**Sandstone Precinct, 23-33 & 35-39 Bridge Street, Sydney
Notice of Exhibition**

Thank you for your letter dated 14 November 2016, requesting Transport for NSW (TfNSW) review and comment on the above.

Concept Stage 1 (SSD 6751 MOD 2) and Stage 2 State Significant Development Application (SSD 7484)

Figure 3 On-street designation of kerb side uses

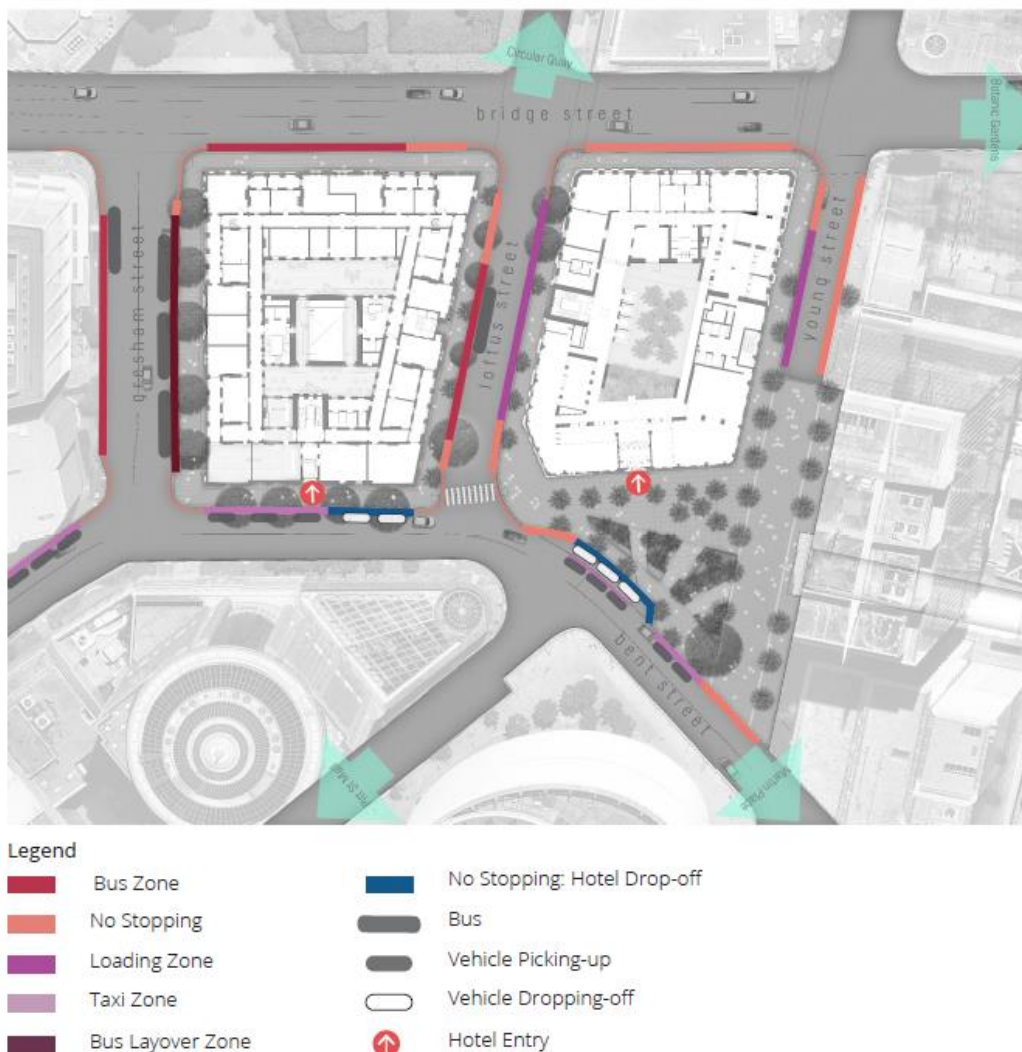
The plans for the precinct show adjustments to the kerbside controls. Several bus routes operate along the streets adjacent to the site. It should also be noted that the City of Sydney are currently investigating public domain upgrades for the precinct, in consultation with TfNSW. TfNSW requests that

- Swept path analysis be undertaken to ensure that bus movements could be accommodated and services are not affected; and
- Any changes to the kerbside controls/adjustments be implemented in consultation with City of Sydney and the CBD Coordination Office within TfNSW.
